CHENNAI METROPOLITAN DEVELOPMENT AUTHORITY
Thalamuthu Natarajan Building, No.1, Gandhi Irwin Road, Egmore,
Chennai - 600 008
Phone : 28414855 Fax: 91-044-28548416
E-mail: mscmda@tn.gov.in
Web site: www.cmdachennai.gov.in

Letter No.C3 (N)/10532/2016 dated: 15.12.2016

Sub: CMDA – Area Plans Unit – MSB (North) Division – Planning Permission Application for the proposed construction of Group Development of Multi-storied Buildings Main Block with Basement floor + Ground floor + 5 floors Hospital Building, Temple with Ground Floor only and Stack parking 4 nos with 6 levels, at Pillaiyar koil strret, Thirumangalam, Chennai - 40. Old S.No.230/7A pt, T.S. No. 8, Block No. 27 of Koyambedu Village. Within the limits of Chennai Corporation – Particulars requested – Reg.

RAMP SECTION - BB'

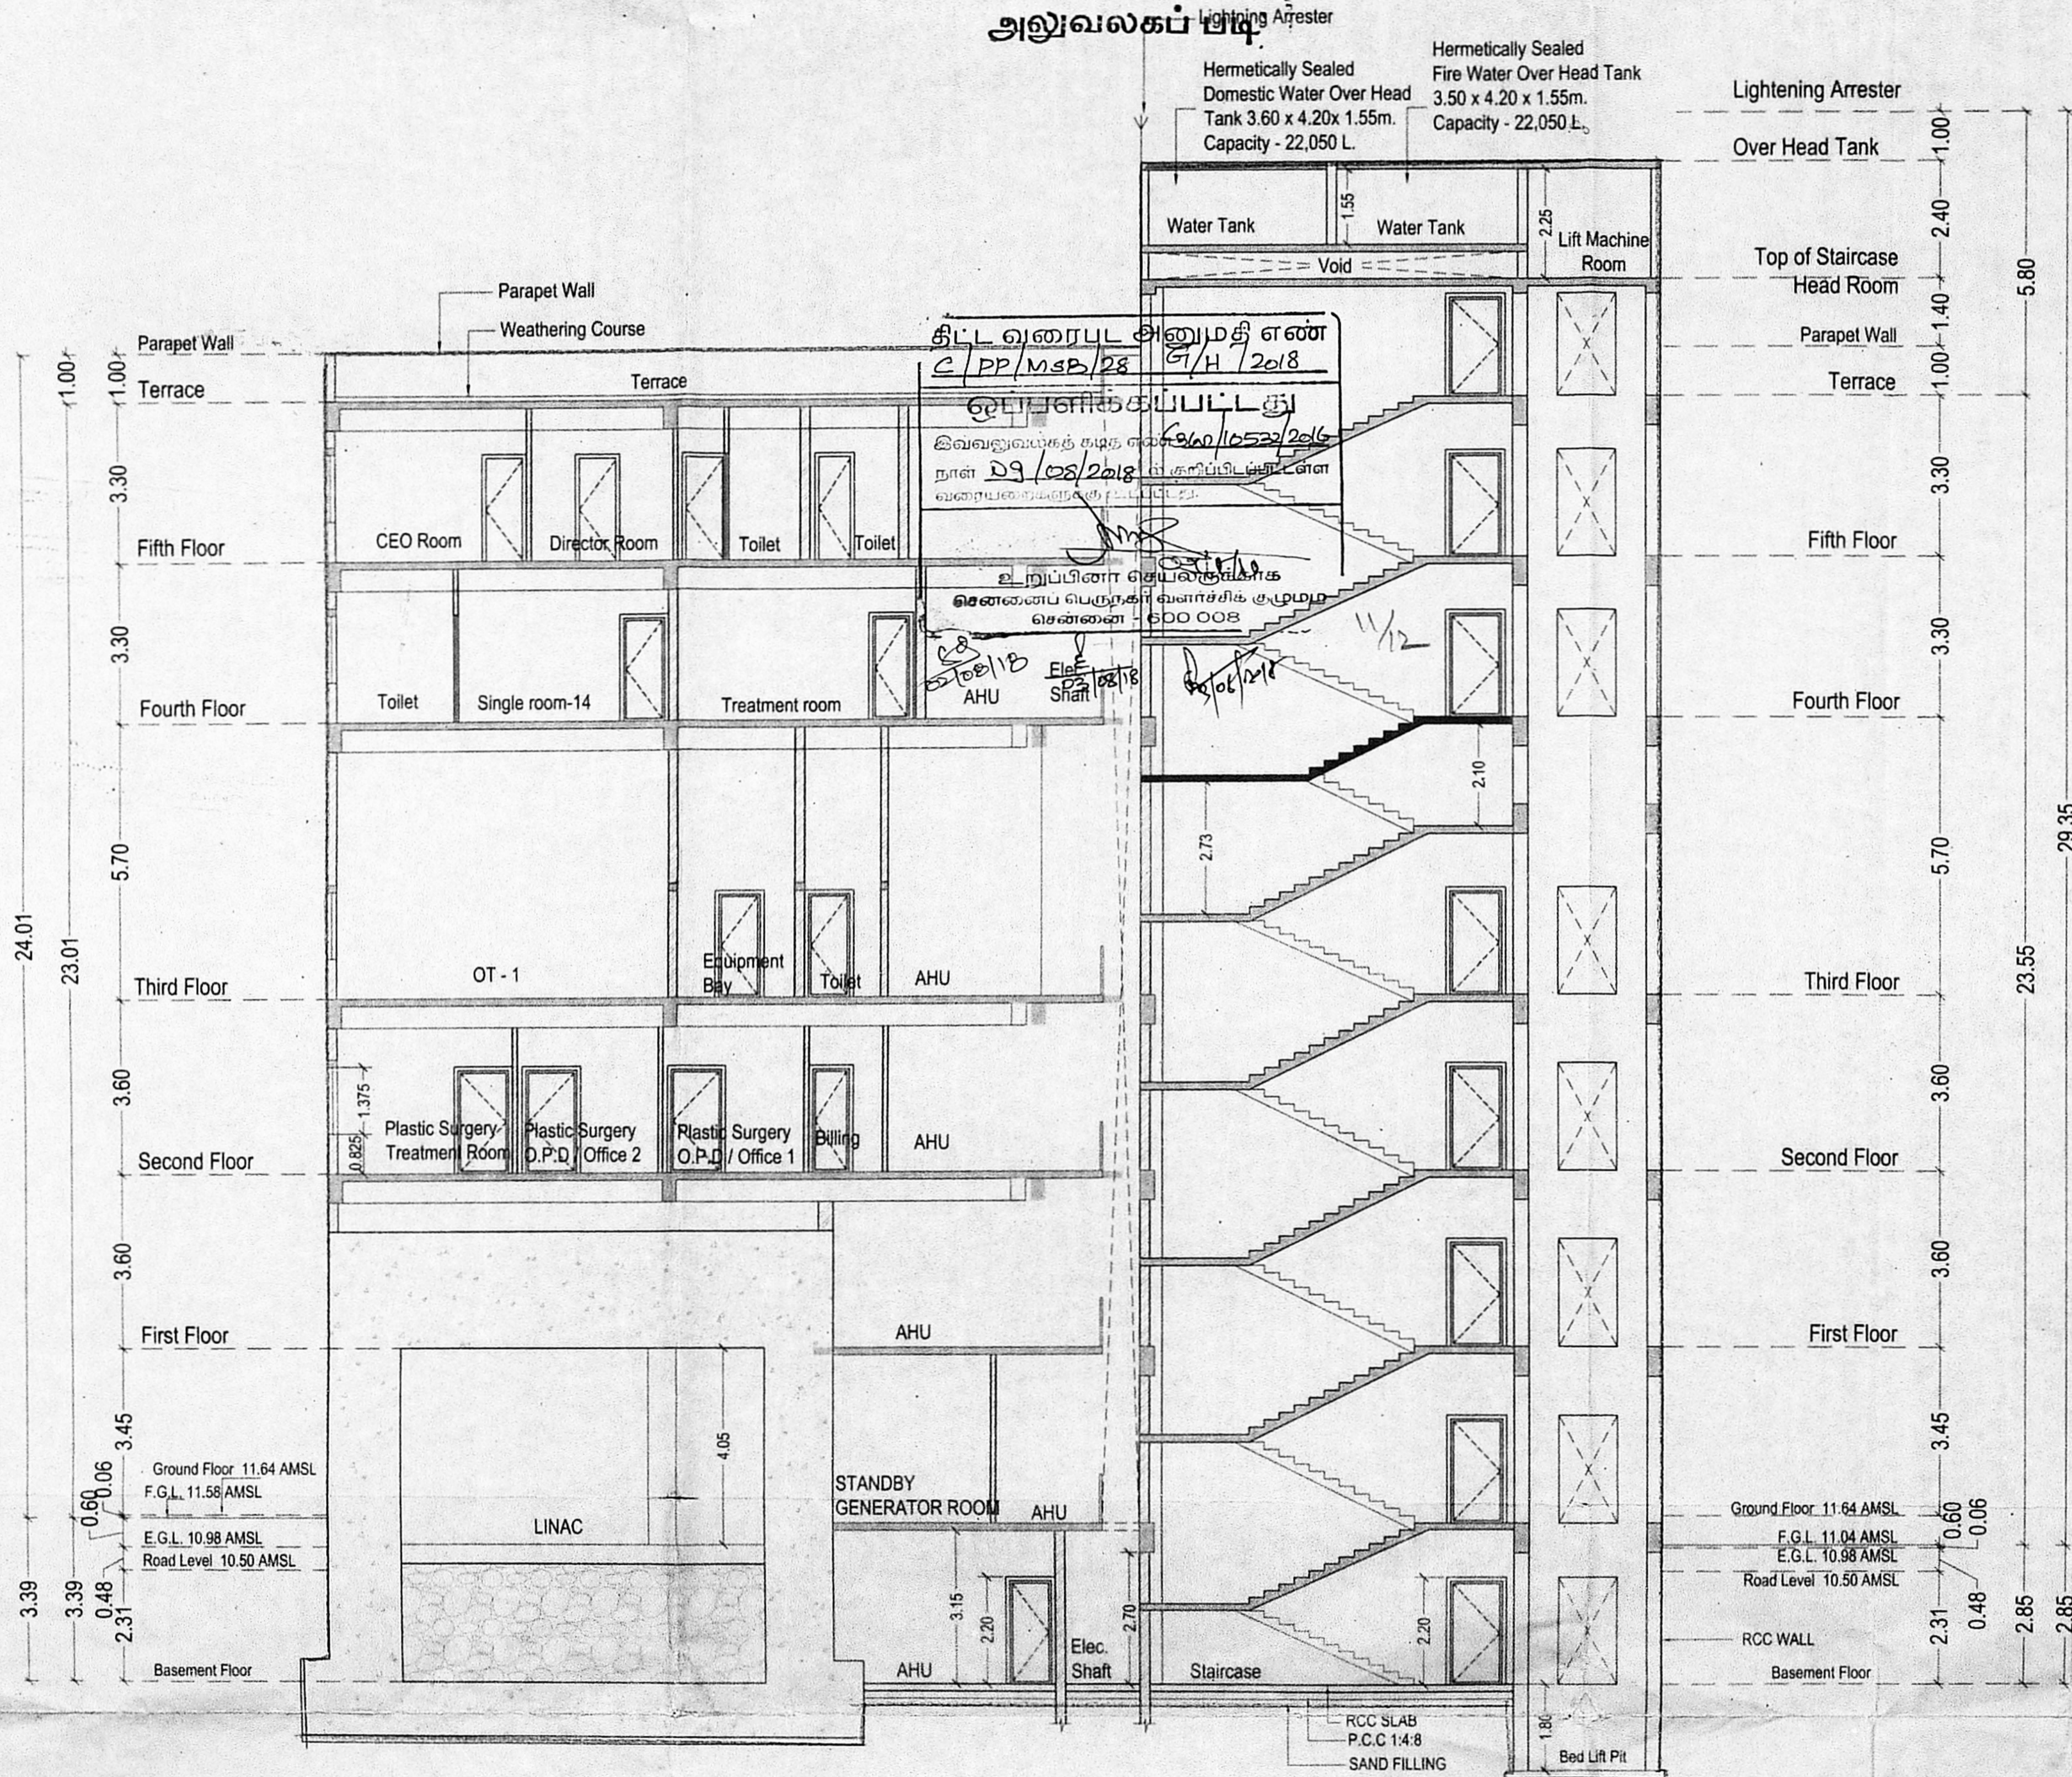
1. Width of ramp 2.40 m and length satisfying 1:12 slope in all floors to be provided and to be specified as fire escape ramp in all floors and entrance landing width to be shown as 2.40 m in all floor plans and car parking is Less by 7 nos as per DR requirements.

8. Plan incorporating DF&RS conditions to be shown.
9. GL shown at north east corner of the building at G.floor not tallies to be removed.
10. Ramp entry shown to B.Floor shown in the G.Floor & in the site plan is not tallies. Further the entry shown at G.Floor from the gradient proposed area ie. At 0.90 m to 0.45 m is not feasible.

TEMPLE - FLOOR PLAN

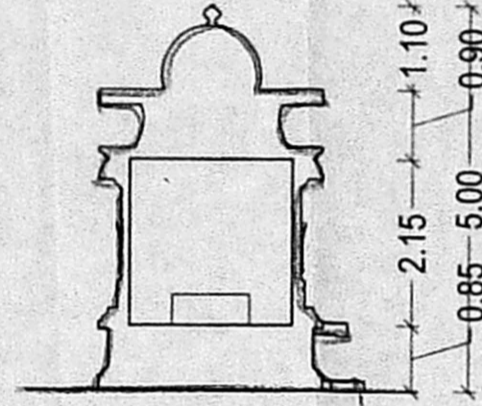
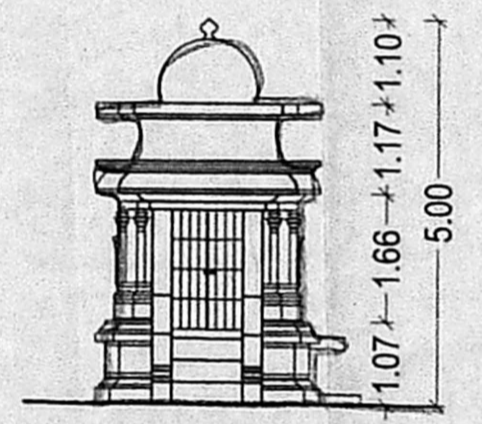
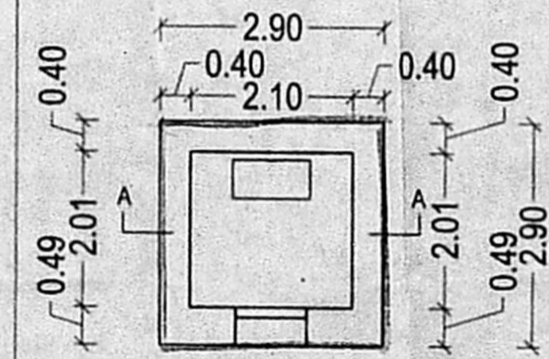
2. Minimum set back of 6.00 m required for Temple & Min. required setback as per DR for stack parking are to be shown and detail drawing for stack parking to be furnished.

3. Sizes of temple building & Stack parking along with detail drawing to be furnished and set back and distance between the blocks satisfying D.R to be shown for the both the blocks.
